BUILDING CODE OF AUSTRALIA REPORT

**North Shore Private Hospital
Westbound Street, St Leonards NSW**

Date	Revision Number	No. of pages	Issue or Description of Amendment	Checked By	Approved By	Date Approved
19.08.16	01	16	Preliminary Report	Matt Marks	Vanessa Batty	19.08.16

Drawing Title
LOWER GROUND LG3 FLOOR PLAN

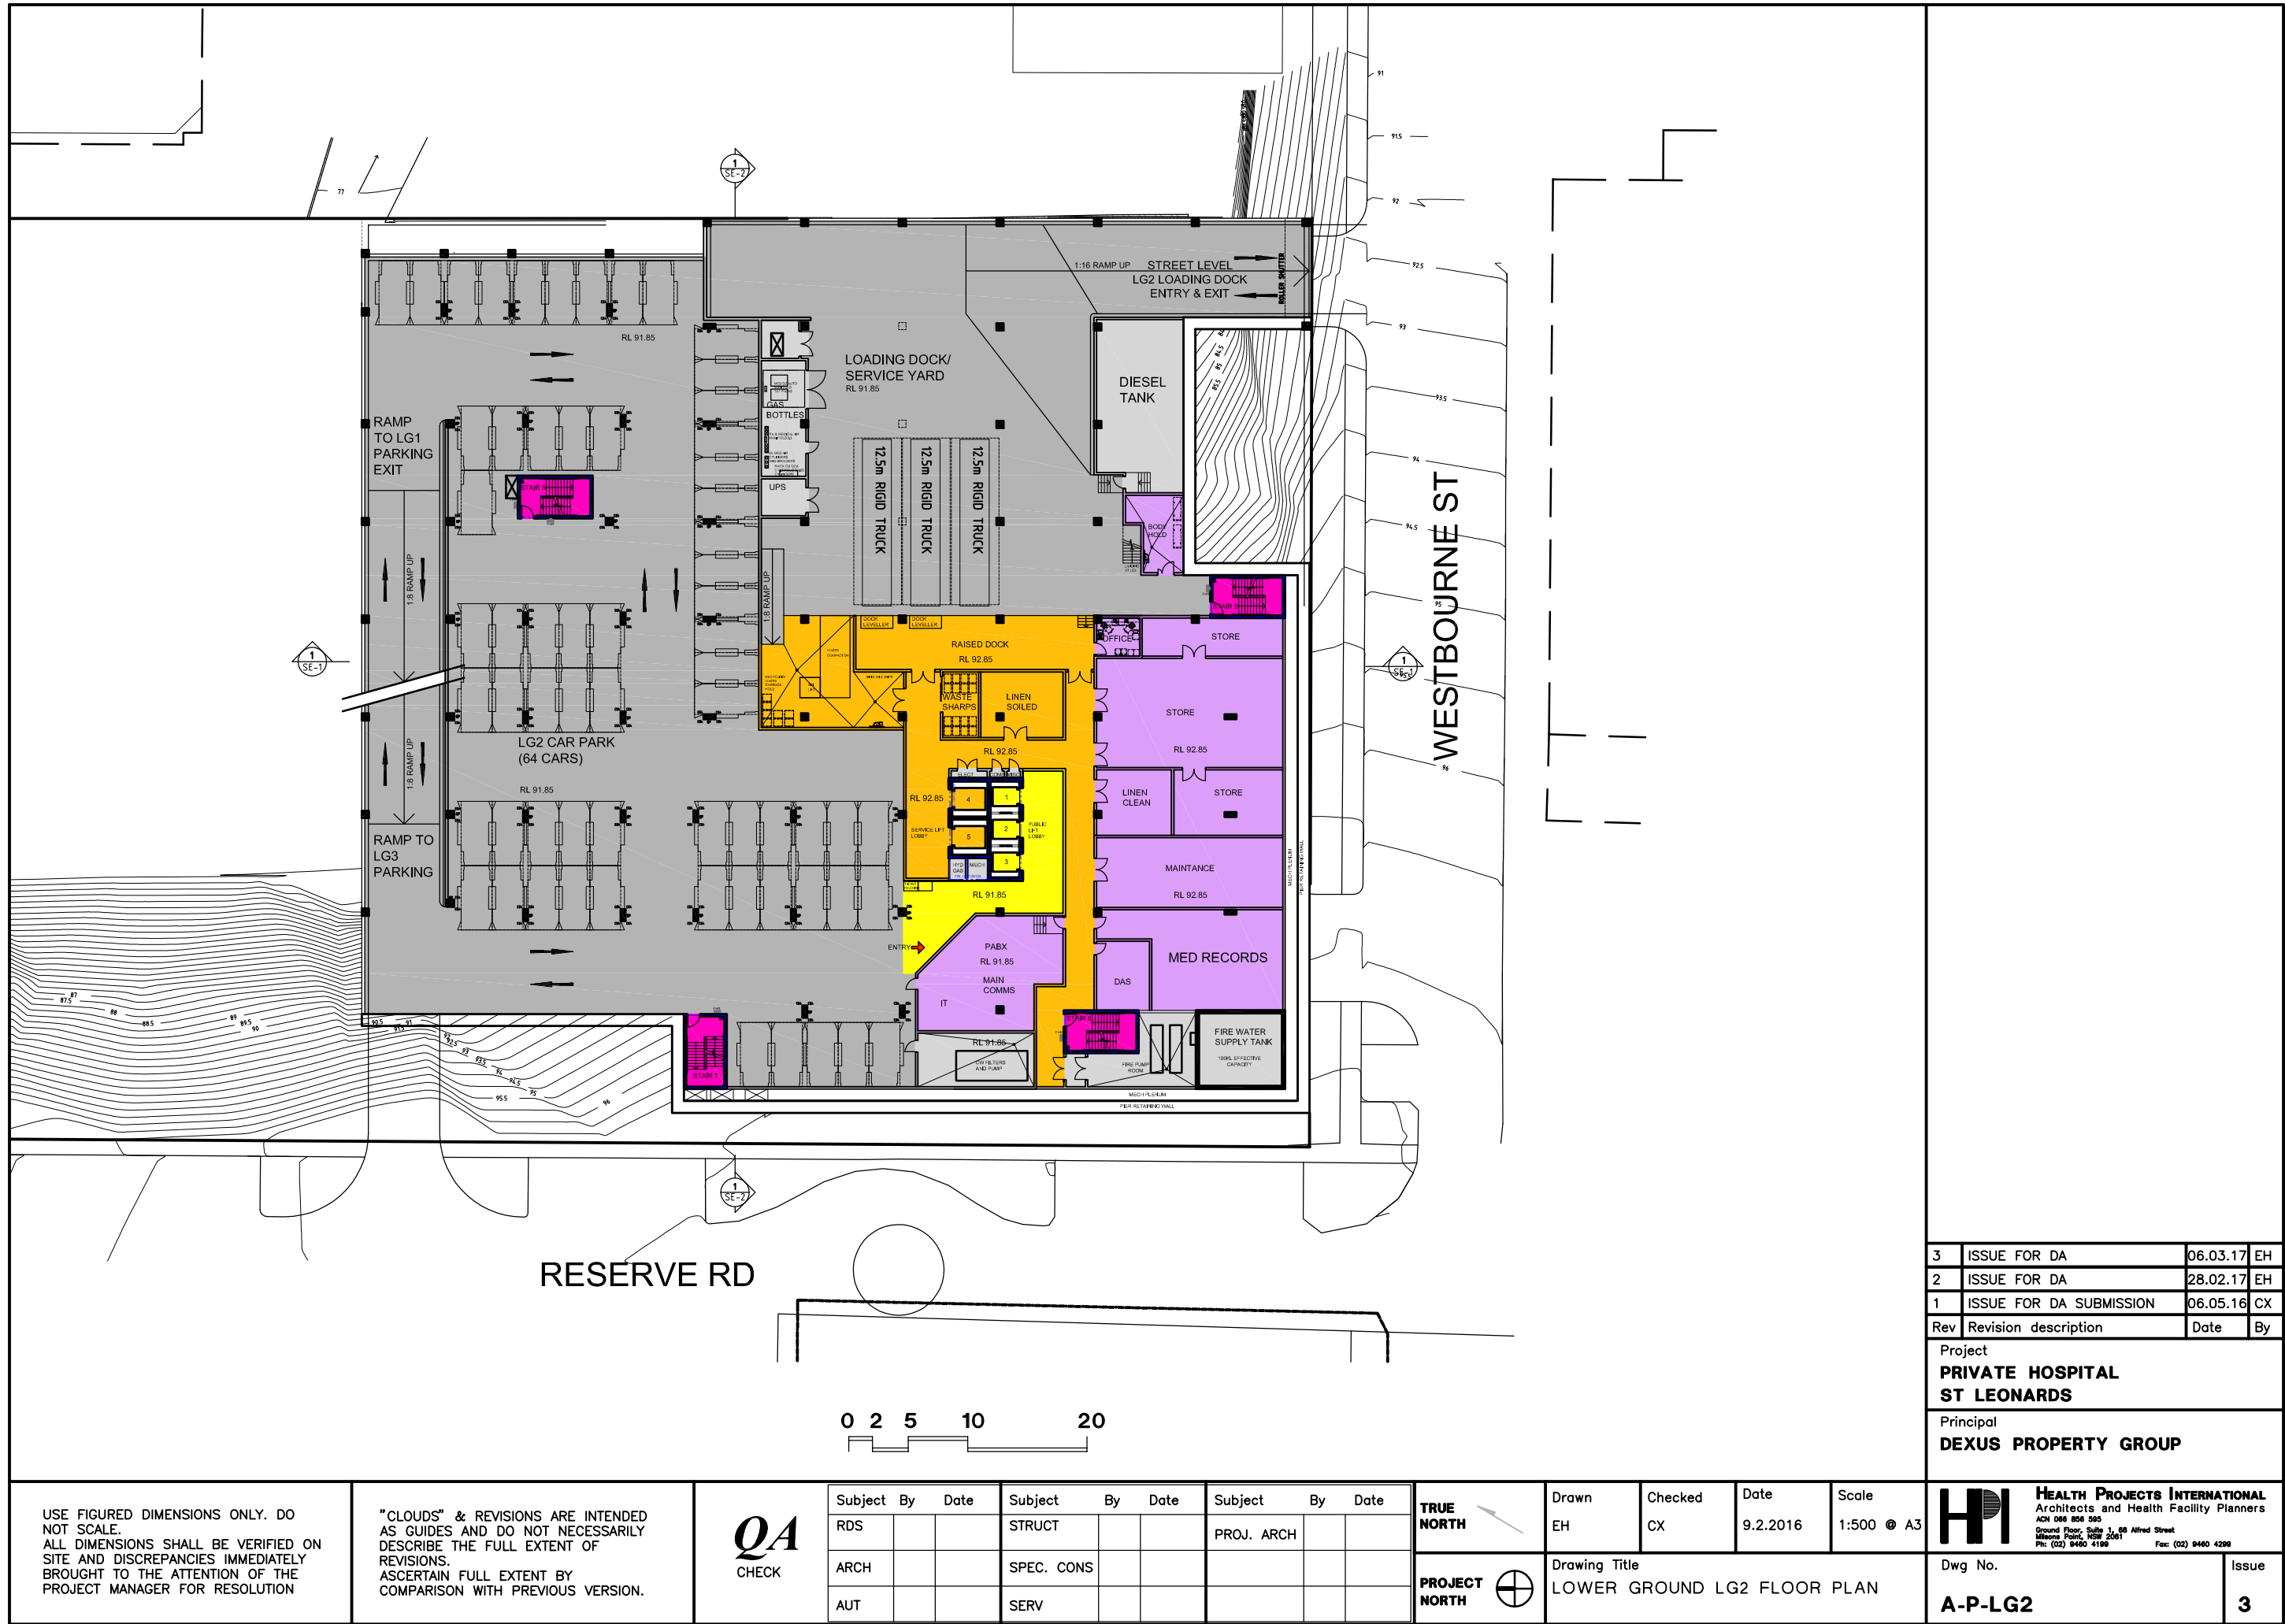
- LG3 - the size of the fire compartment was identified as being 5550m² which is greater than the 5000m² prescribed in the deemed-to-satisfy provisions of the BCA.
- LG2 - the size of the fire compartment was identified as being 5719m² which is greater than the 5000m² prescribed in the deemed-to-satisfy provisions of the BCA.
- Ground Floor to level 6 – Patient Care areas are adequately divided into fire compartments not exceeding 2000m², Smoke proof walls are required to divide the floor area into <500m² floor areas.

The above mentioned fire and smoke compartments which currently exceed the prescriptive requirements of the BCA, are to be addressed through a revised architectural design and / or in consultation with the Fire Engineer through the development of an alternative solution.
